From: Cherne, Curtis
Sent: Tuesday, March 14, 2017 1:32 PM
To: jeff@amcdevelopment.net
Subject: Independence Square Starbucks Construction site inspection
Attachments: south_edge.jpg

**Re: Starbucks Shell at Independence Square
Erosion and Sediment Control Plan
Engineer's Stamp Date 5-29-18 (E17E076A)**

**Re: Independence Square Lots 1 and 2
Erosion and Sediment Control Plan
Engineer's Stamp Date 12-28-17 (E17E076A)**

**Re: Starbucks at Independence Square
Erosion and Sediment Control Plan
Engineer's Stamp Date 12-27-16 (E17E076A)**

LOT 1 AND LOT 2
GRADING PLAN

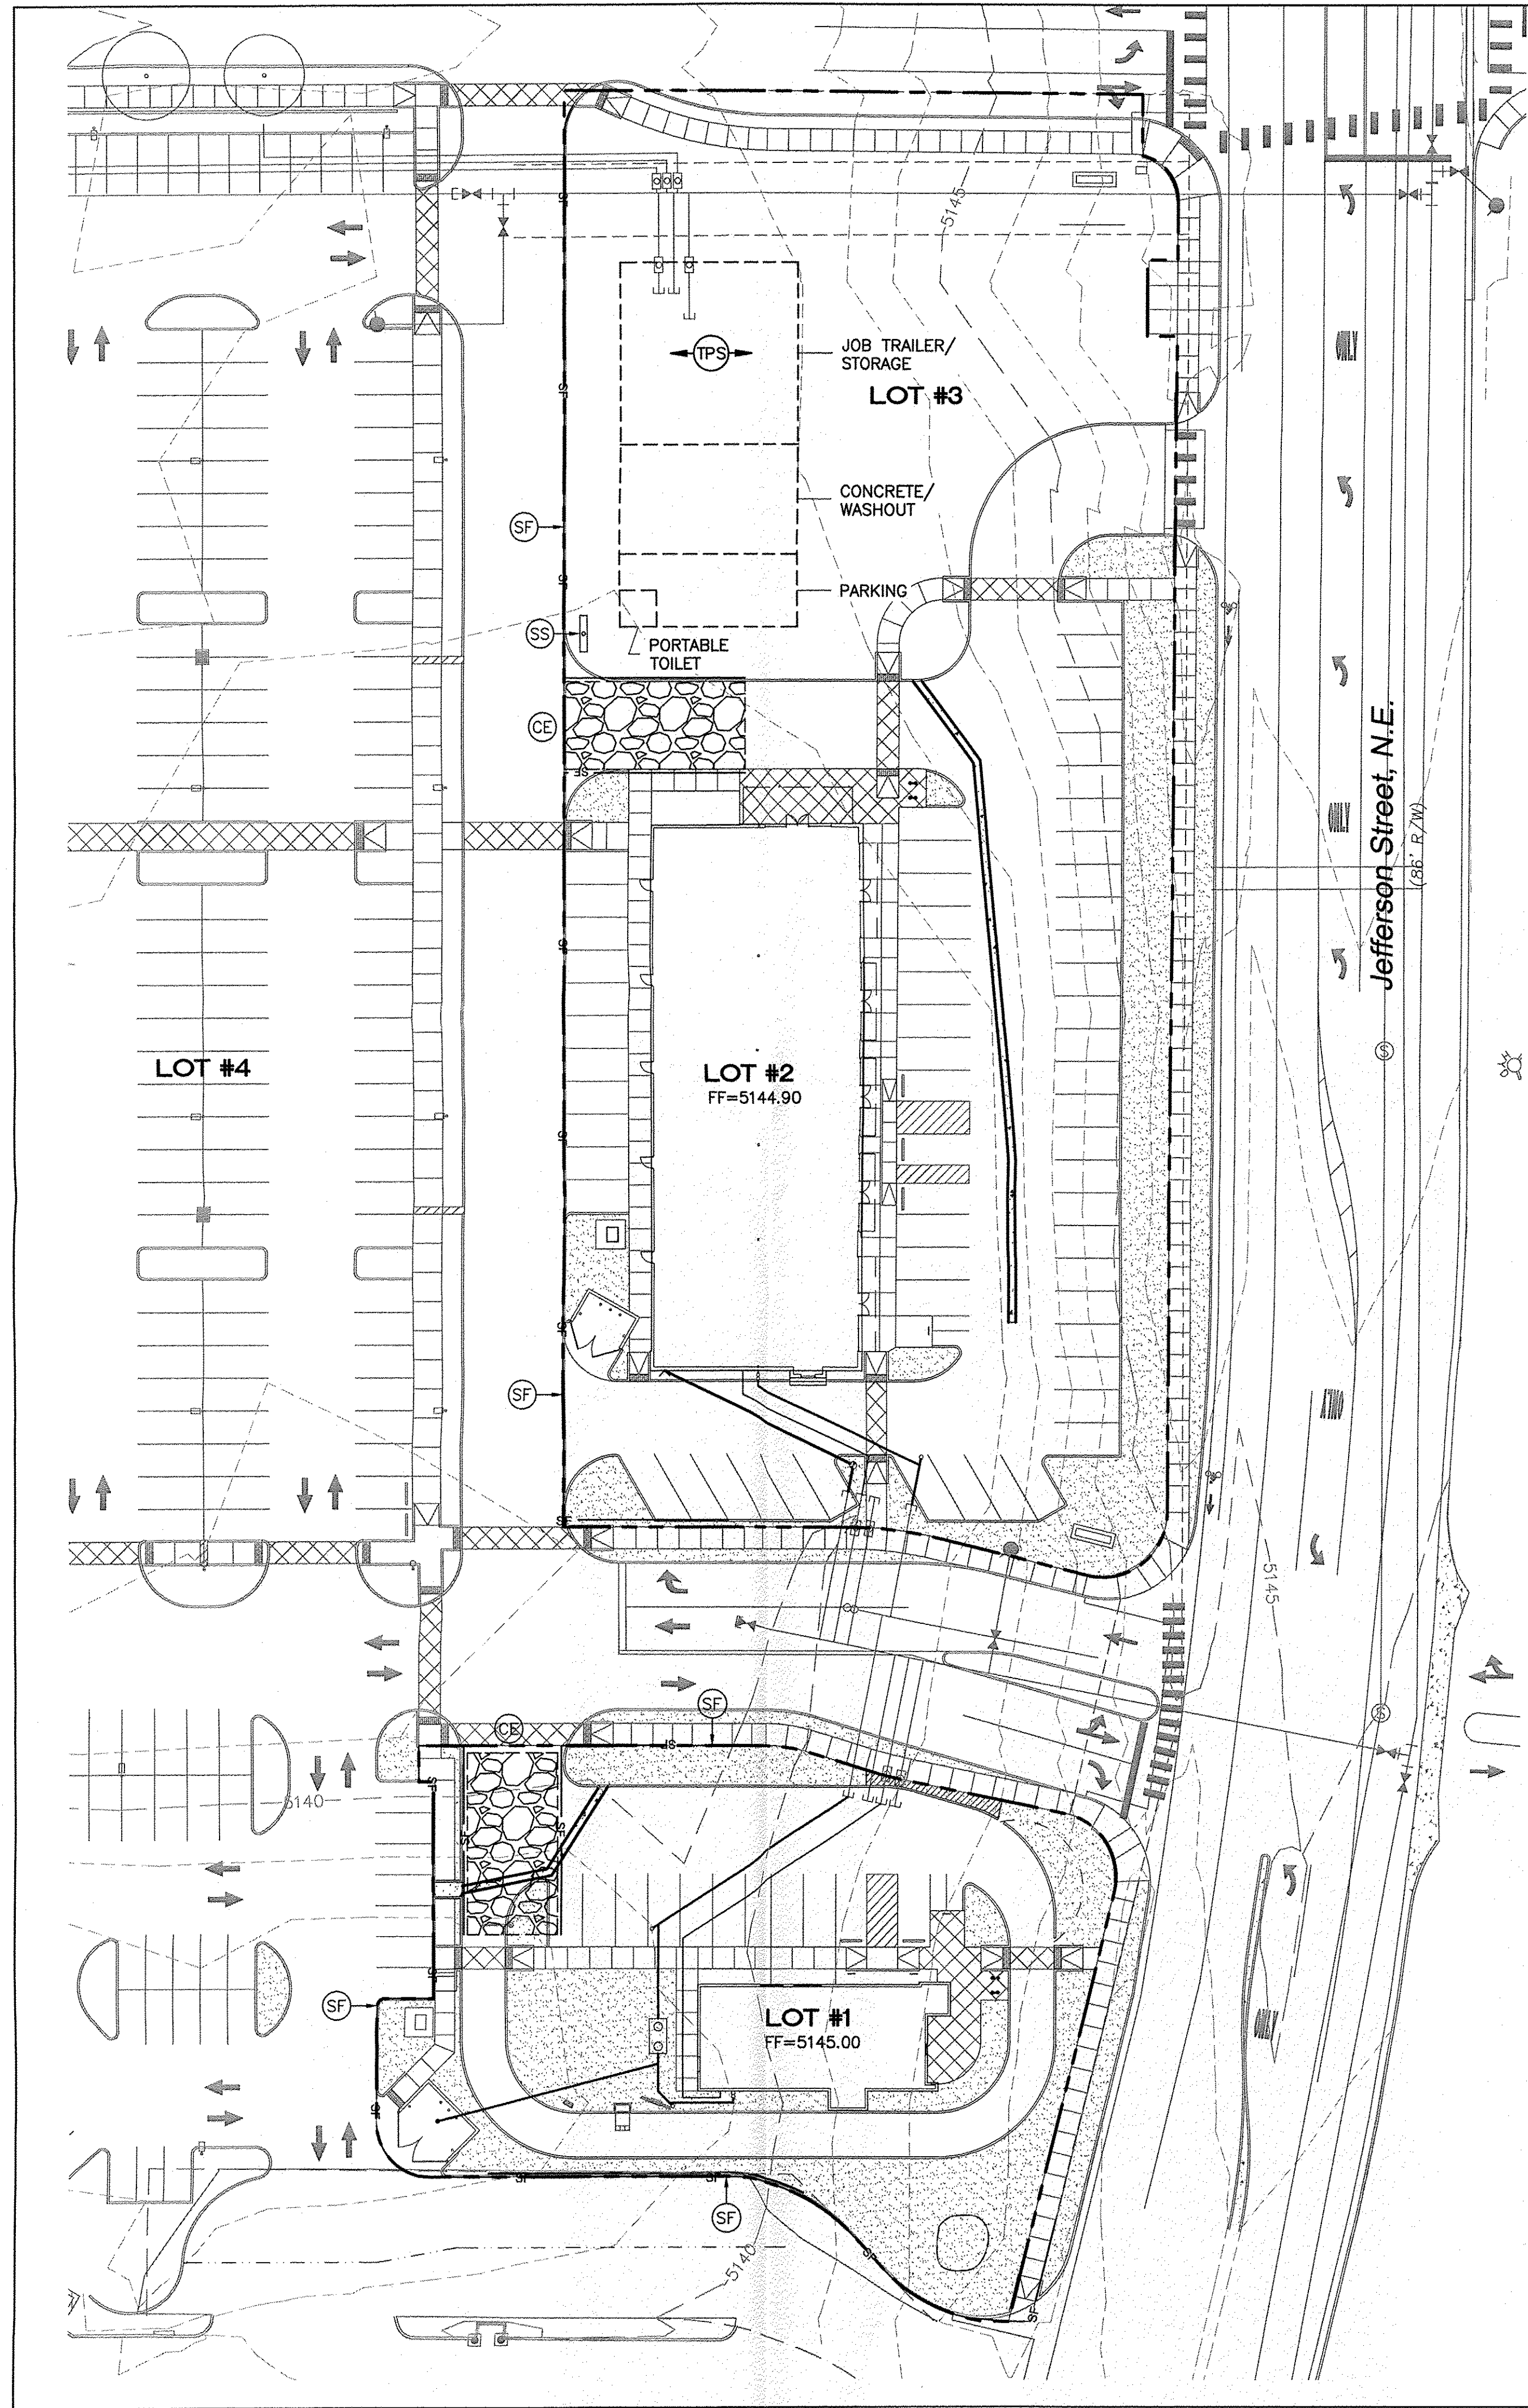
1. When the flatwork is occurring along the western edge of Lot 1, the silt fence should be replaced with a filter sock or similar sediment BMP.

In the future, include grades and build notes from the grading plan on the ESC plan. The simplest way may be to superimpose the BMPs on the grading and drainage plan.

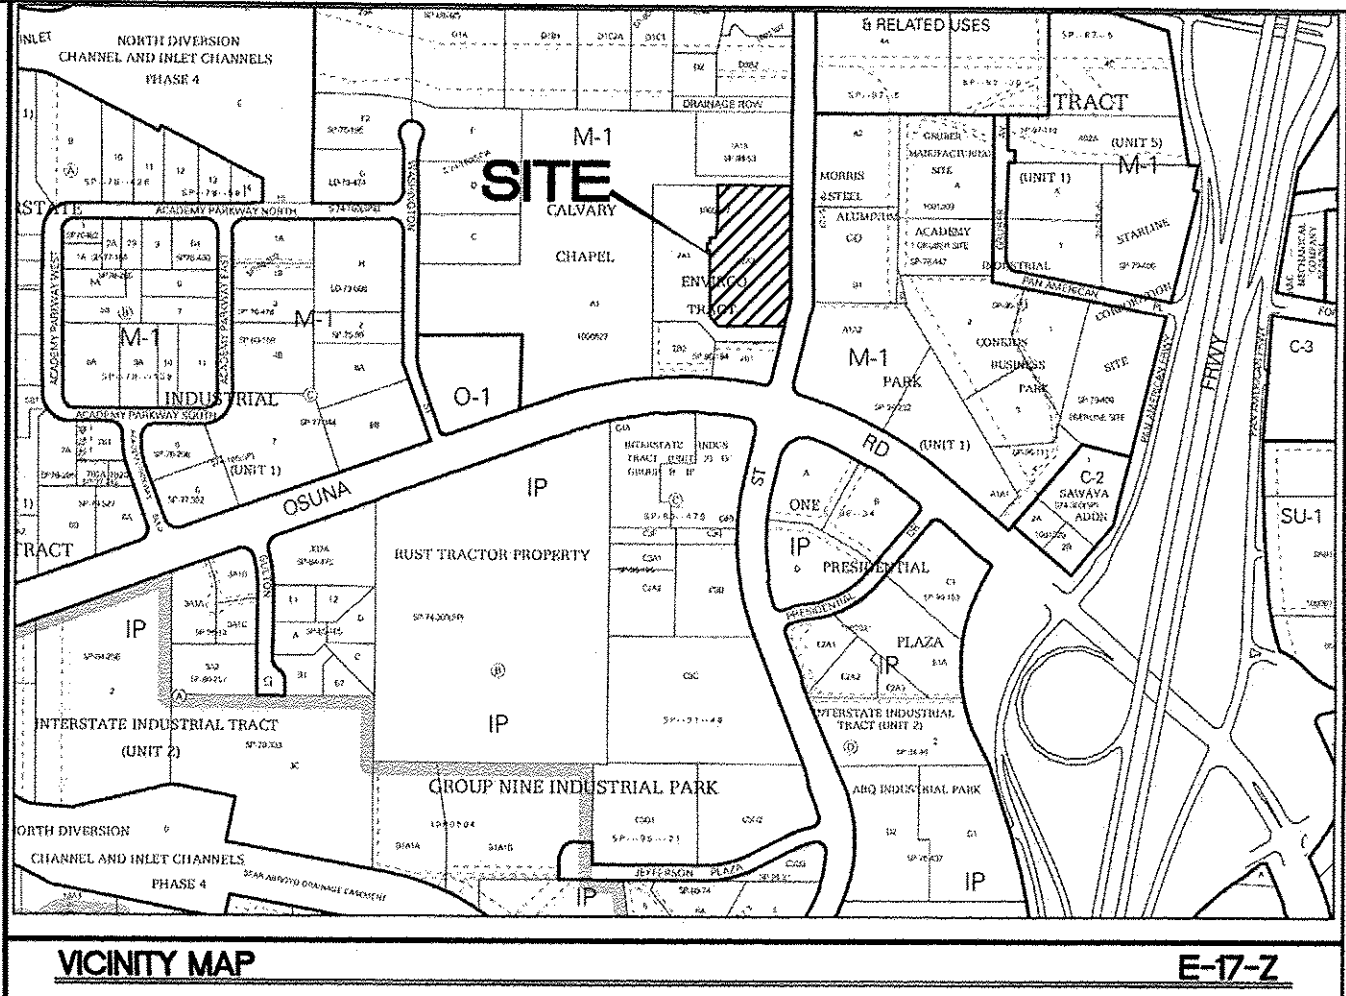
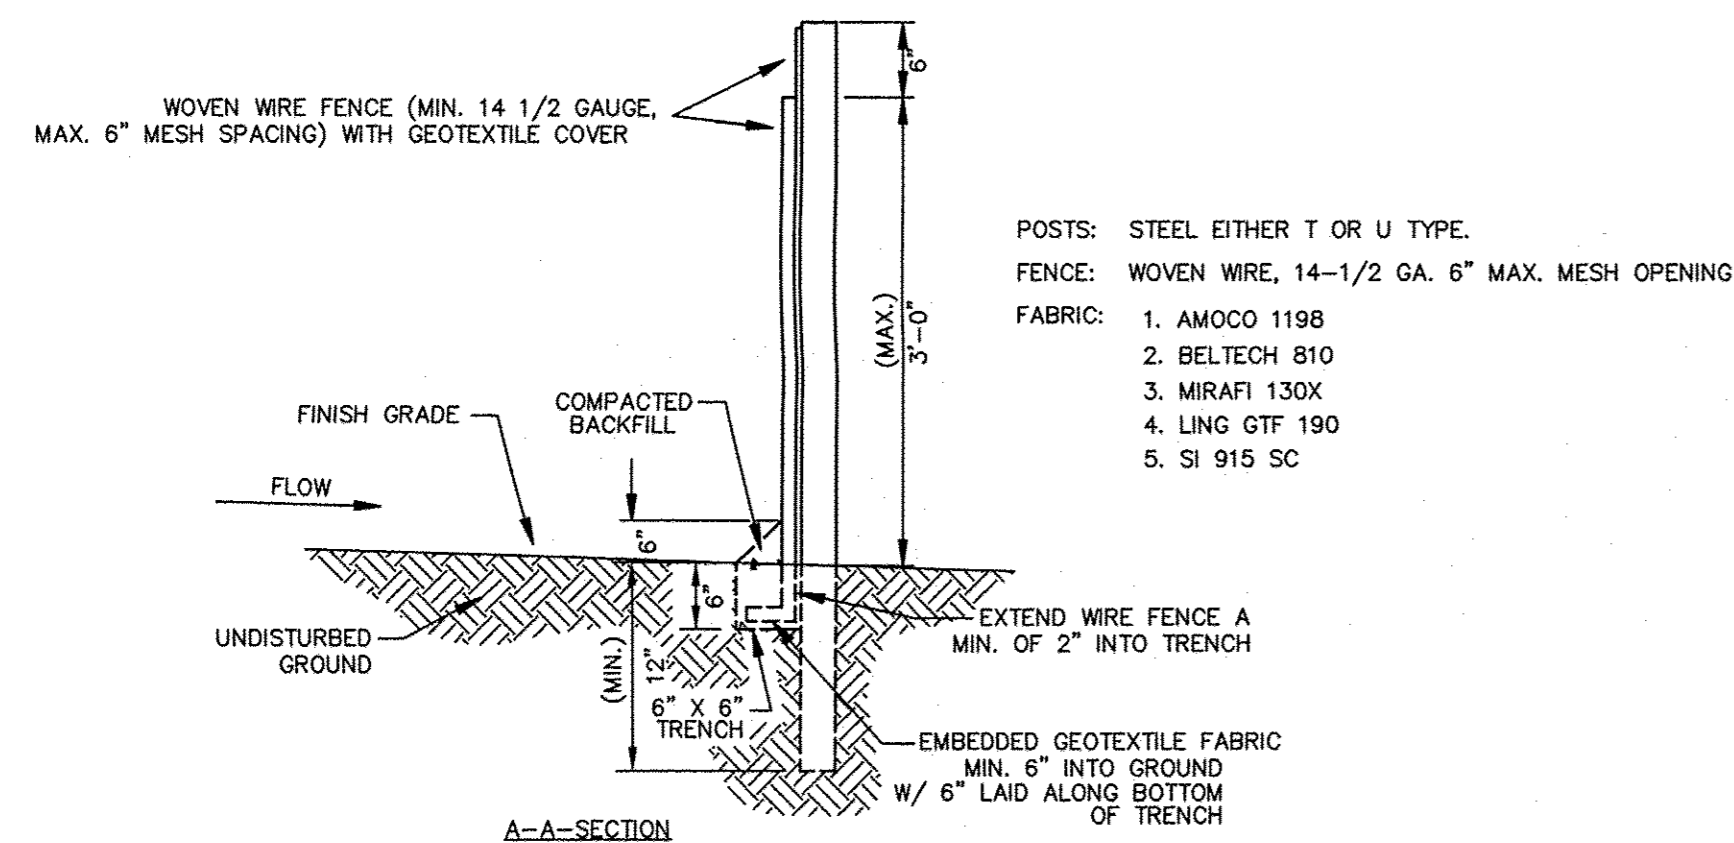
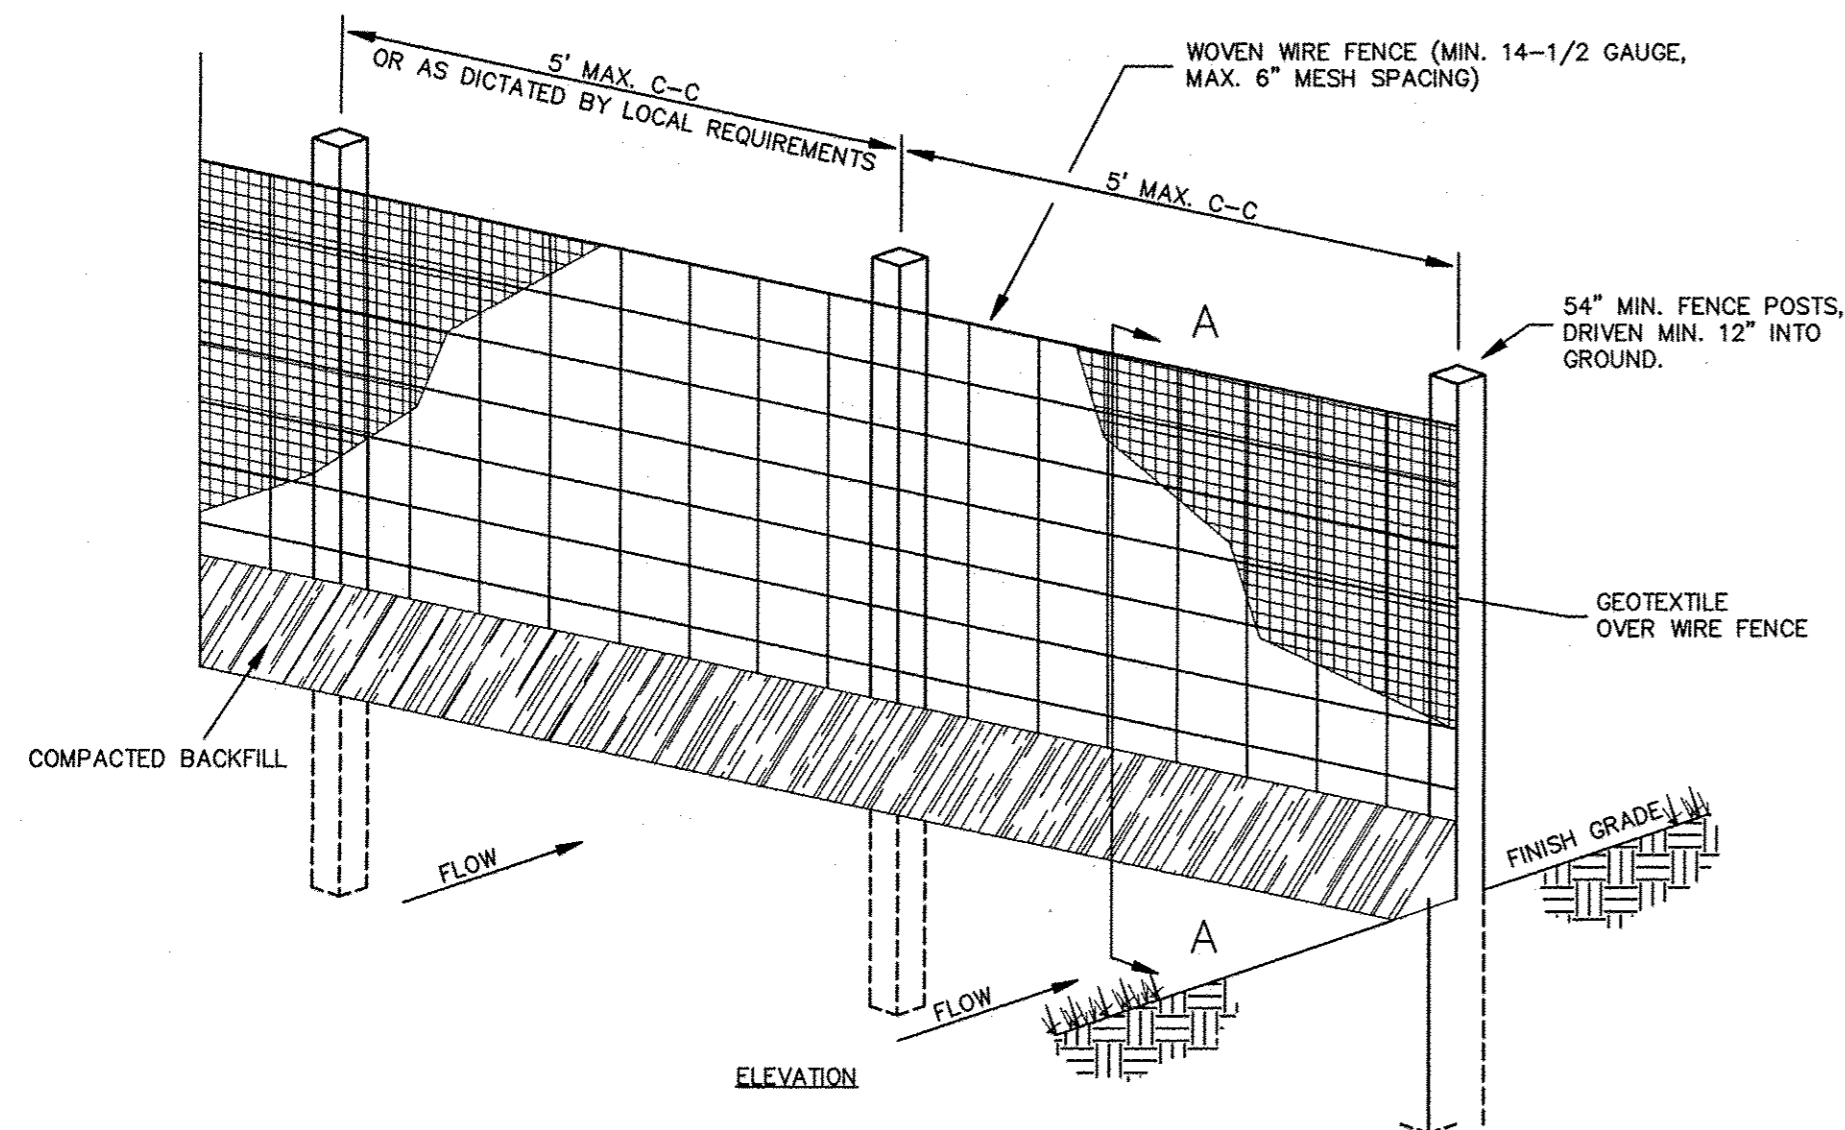
Overall the site looked pretty good and all drive surfaces were nicely swept. However, there wasn't a sediment BMP (e.g. silt fence) along the south side of the proposed Starbucks as shown on the approved ESC Plan. This area drains out to Osuna Rd.
Are you going to be building a wall soon?

The project extents are not clear since there are proposed spot elevations in drive aisles and parking spaces outside the building envelope shown on the ESC plan. Please clarify.

1. The silt fence should be replaced with a filter sock or straw wattle south of the building on the existing asphalt. Silt fence can't be buried in asphalt.
2. Place a filter sock at the downstream end of the channel that runs through the landscape area west of the building.
